RE: Transmittal of Comments – Boat Ramp Short Plat (SP-14-00004)

Subject: SP-14-00004 – Boat Ramp
I-90 MP 136.5 Left vicinity

RE: Boat Ramp Short Plat, SP-14-00004

R/W SR-90/157

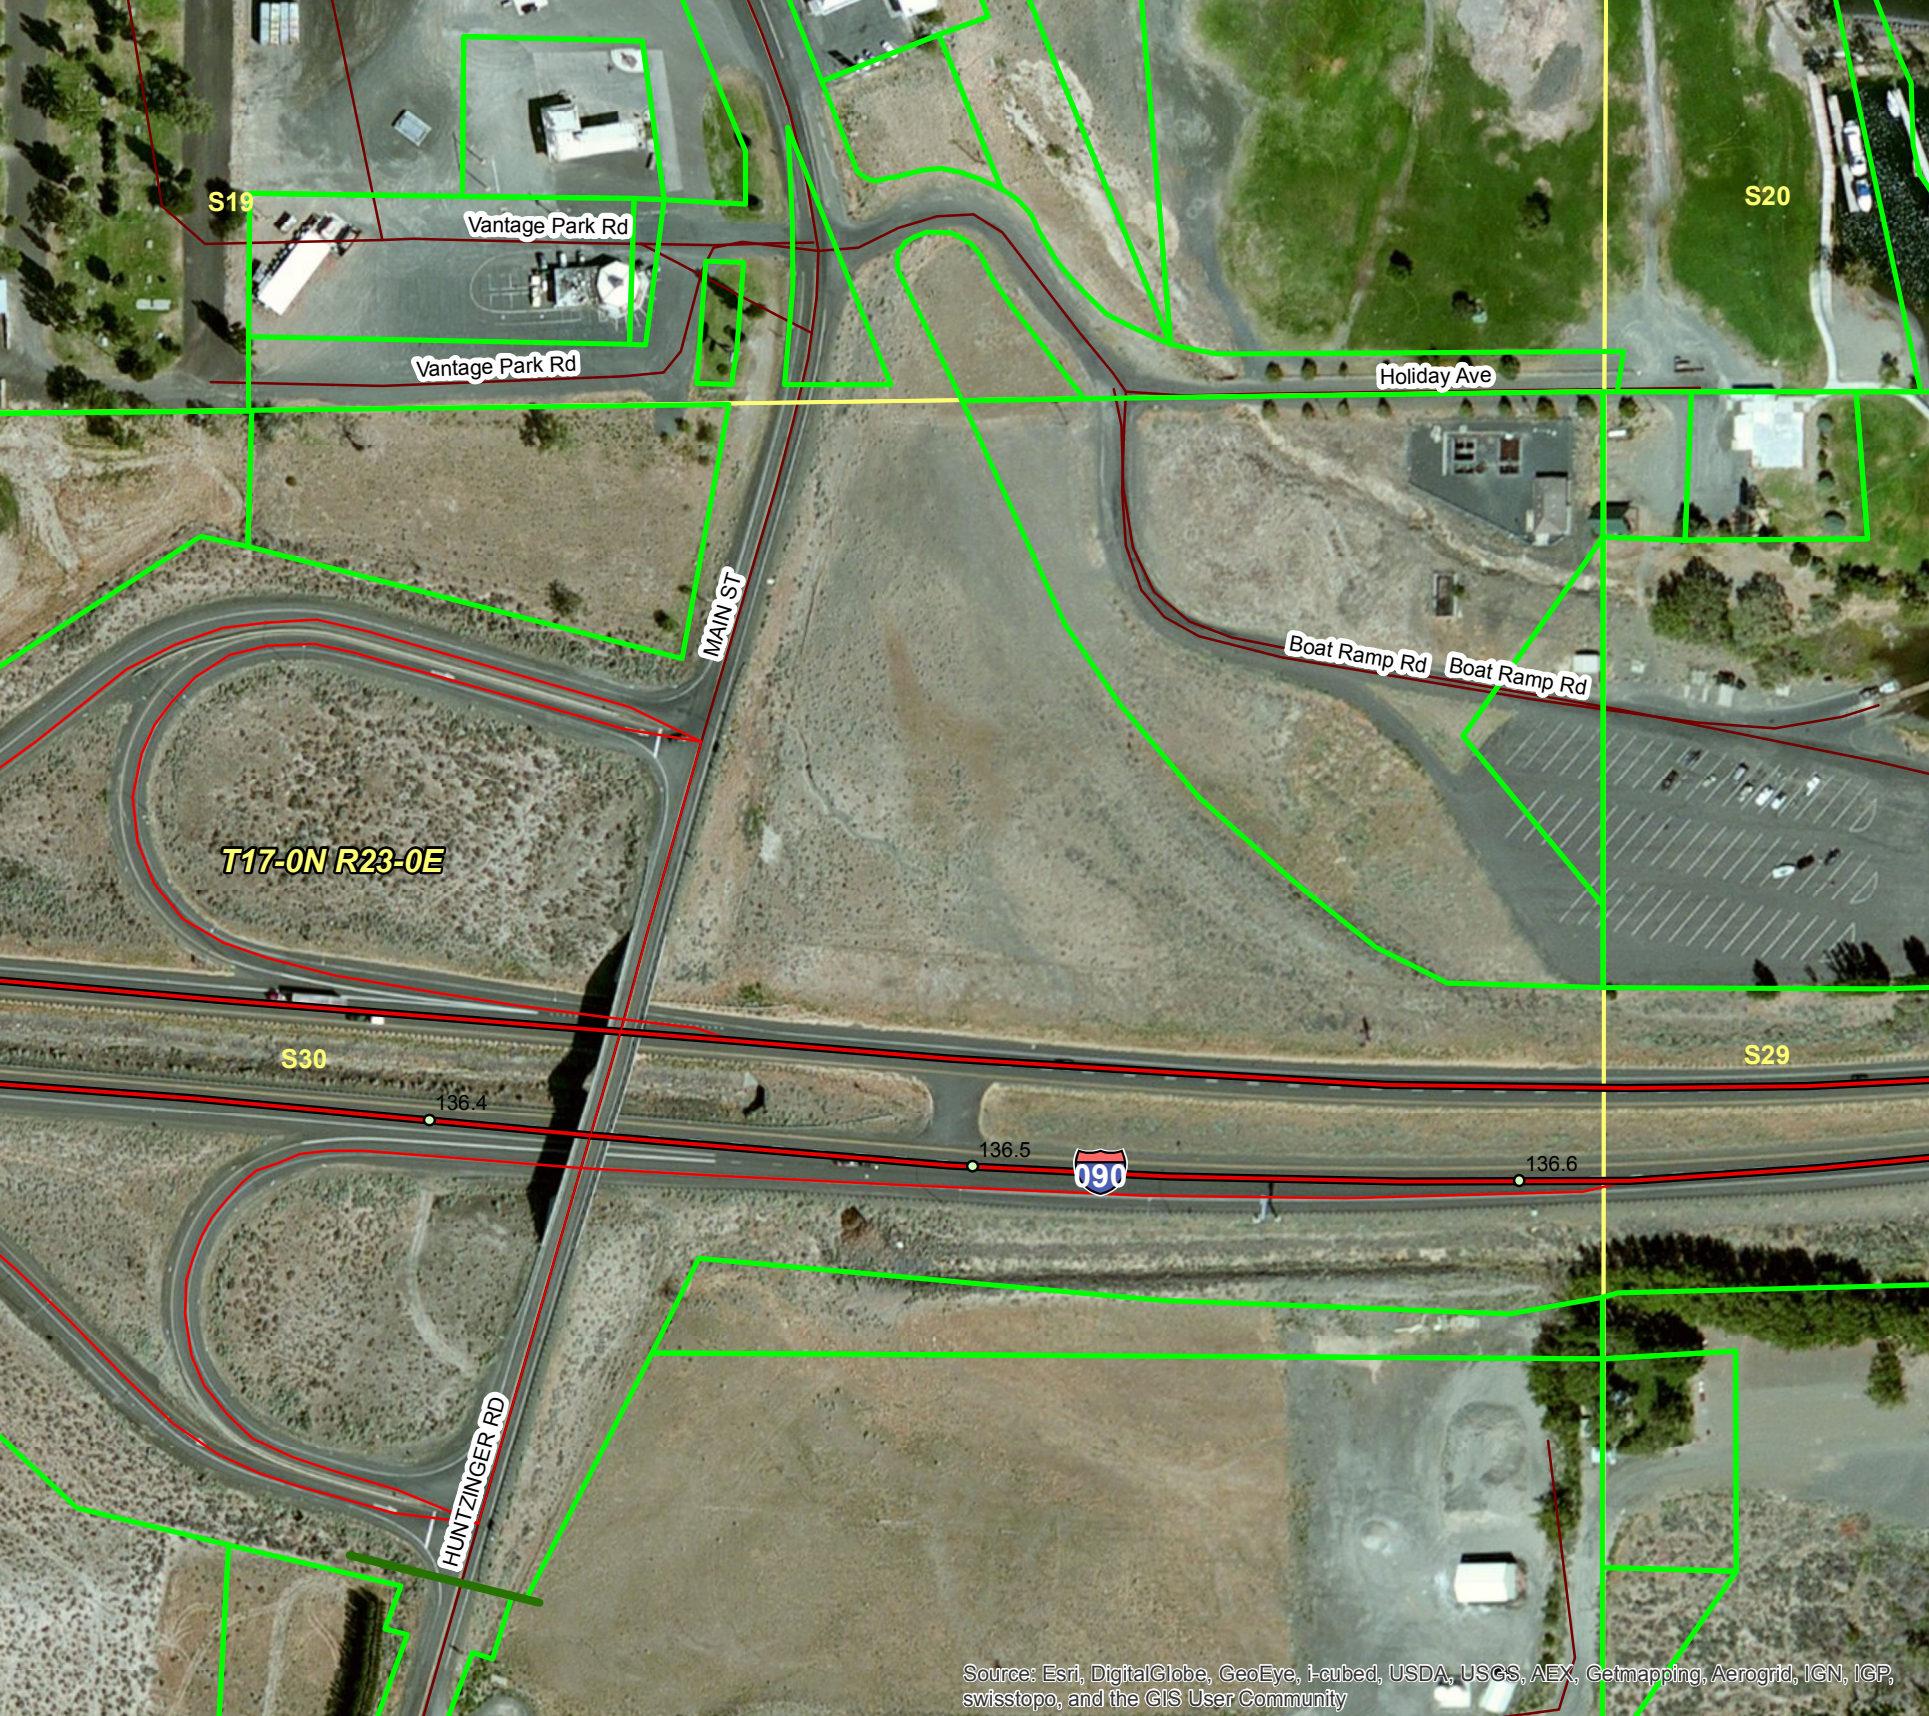
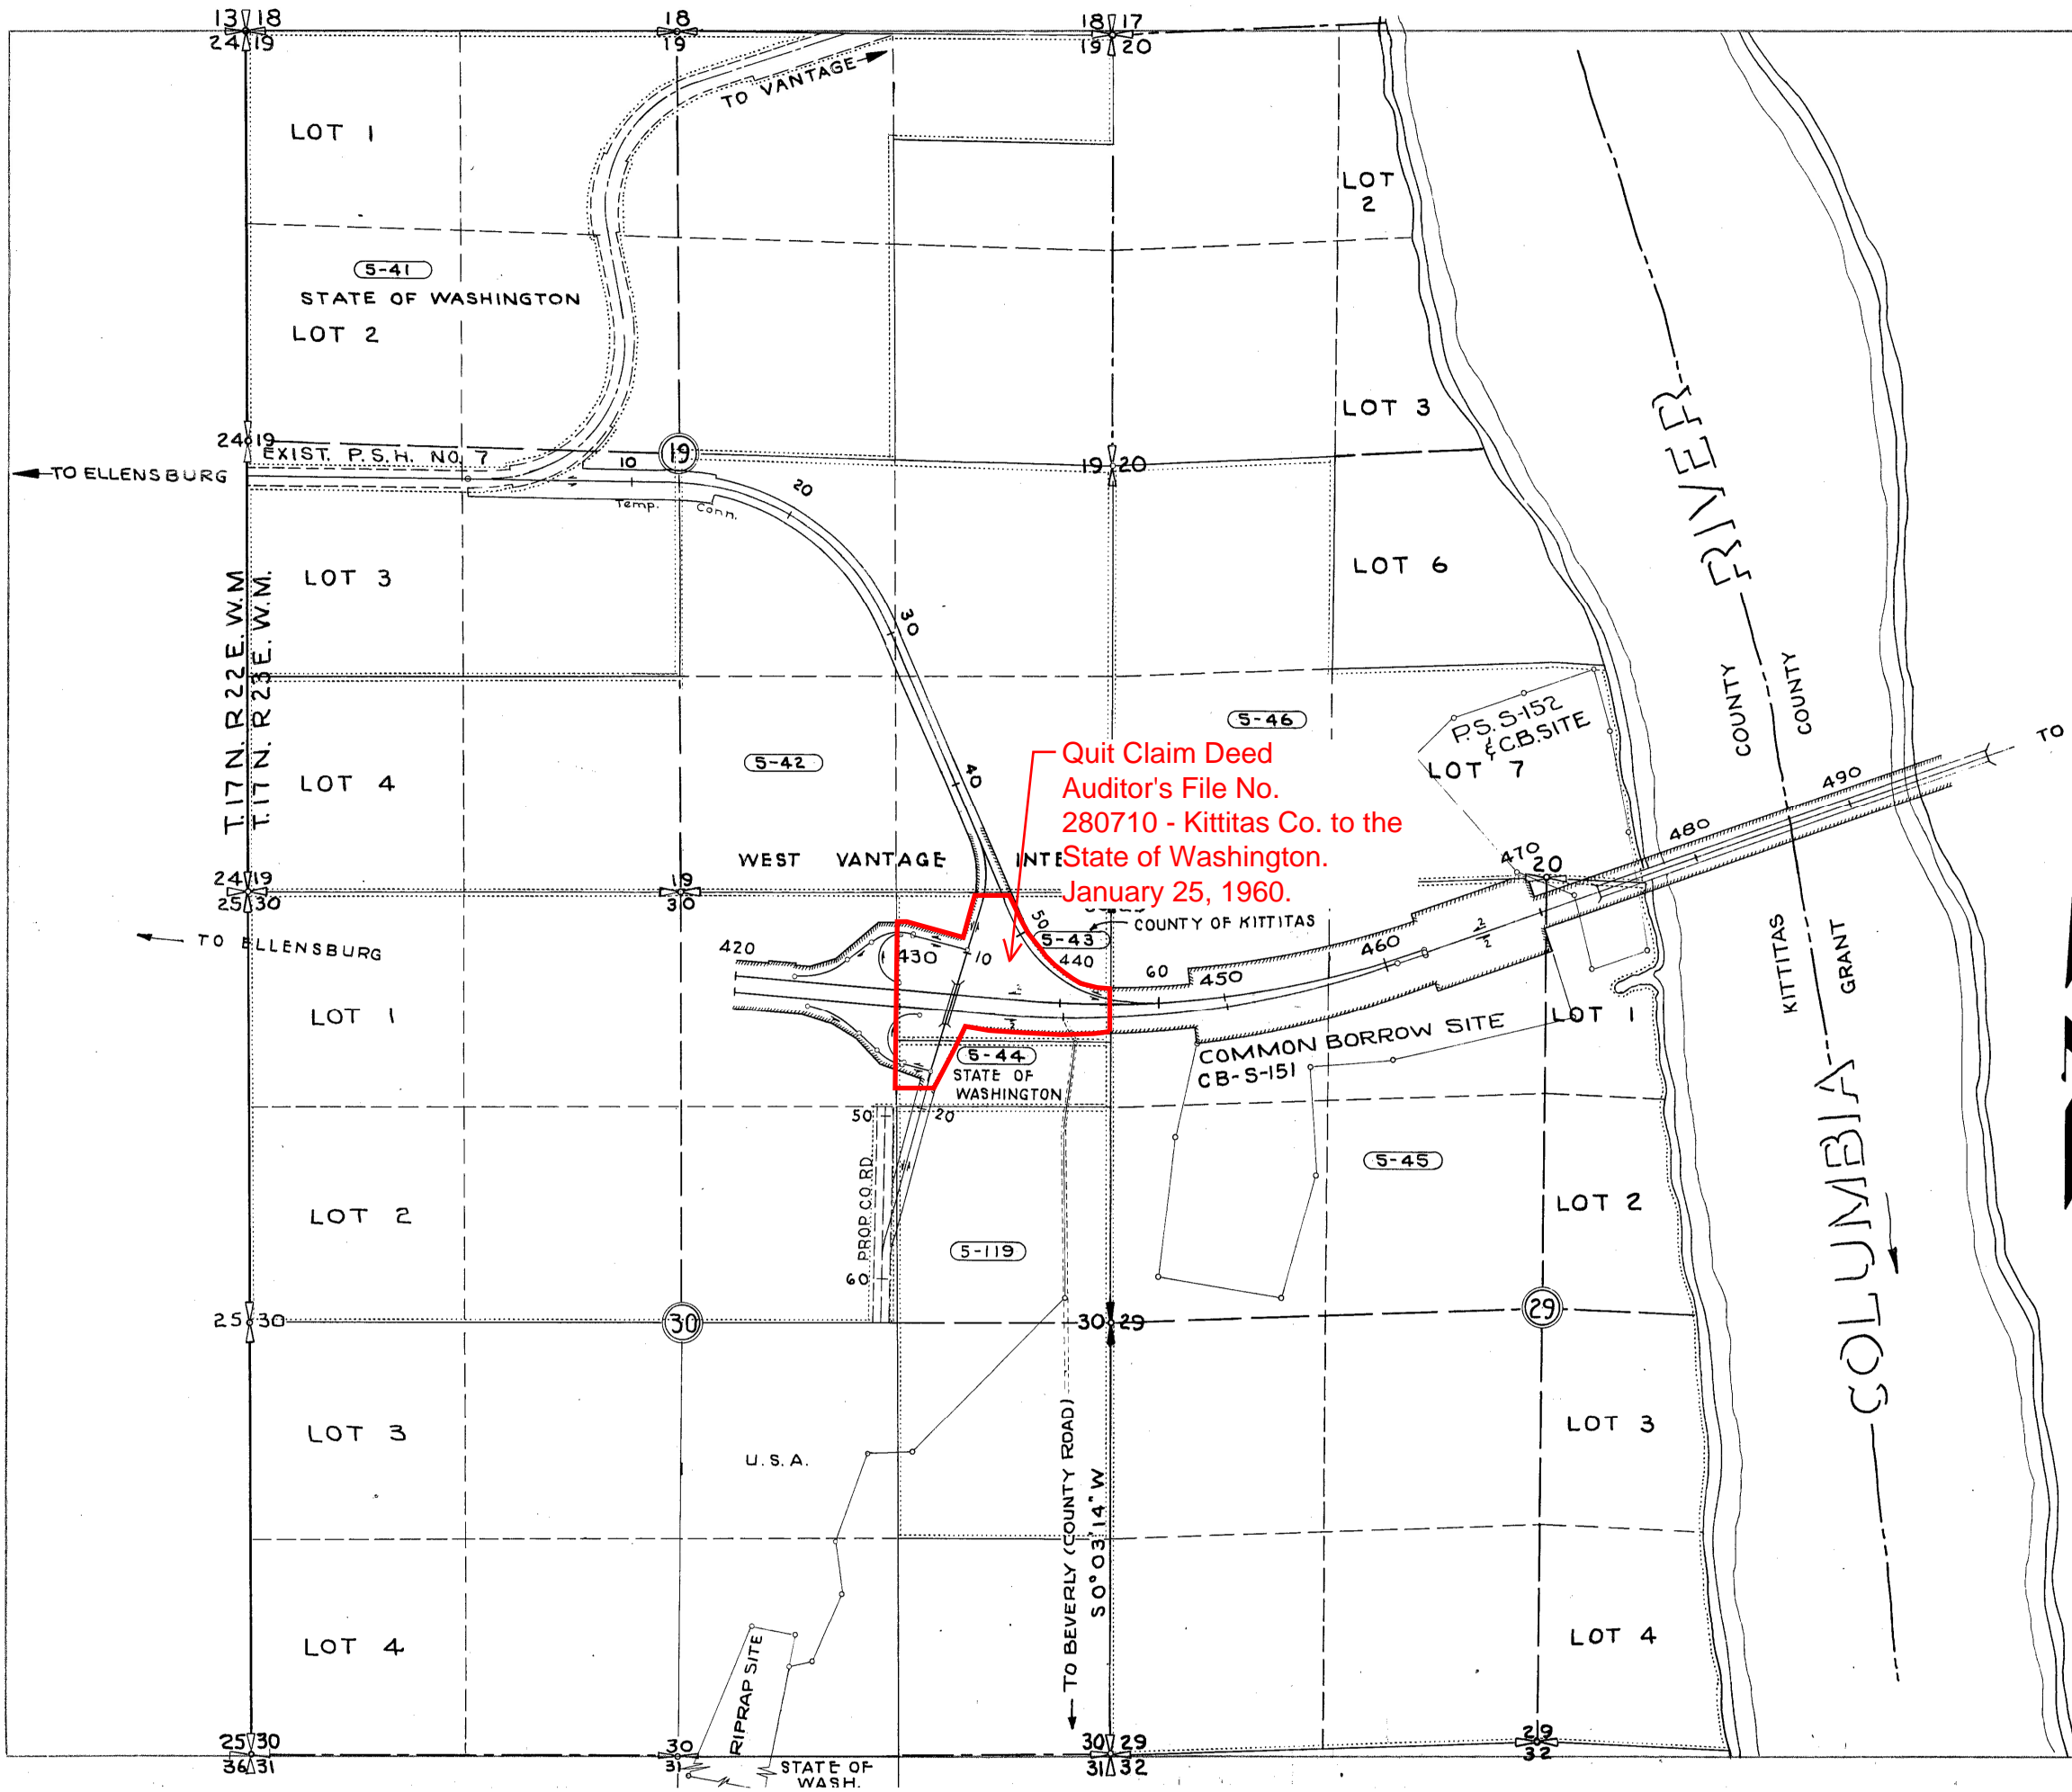
WSDOT finds ownership issues with this proposal. Our records indicate that WSDOT owns a significant portion of this land. From the proposed short plat, it is the majority of lot 3. I have attached the conveyance deed (AFN 280710) and boundary trace of this deed. We have no records indicating other than our ownership. Also attached is the GIS parcel mapping which more or less, is consistent with our records.

I spoke to Chris Cruse yesterday, who referred me to the title report. Within this report, it identifies a number of conveyance deeds after 1960. I guess it is possible that one of these may be a conveyance of property from WSDOT back to the County, but we have no record of this and our right-of-way plan (attached) has no reference to any conveyance back to the County. We note the reference to "4.22 acres of excess r/w" on this plan but have no record of change in ownership.

I checked the certification of the Vantage highway back to the County in 1966, and that certification begins at VE 2+80.8. Meaning, that process did not convey or relinquish ownership of the property in question.

In the absence of a deed or some other instrument indicating otherwise, WSDOT is the owner of the majority of this property in the short plat.
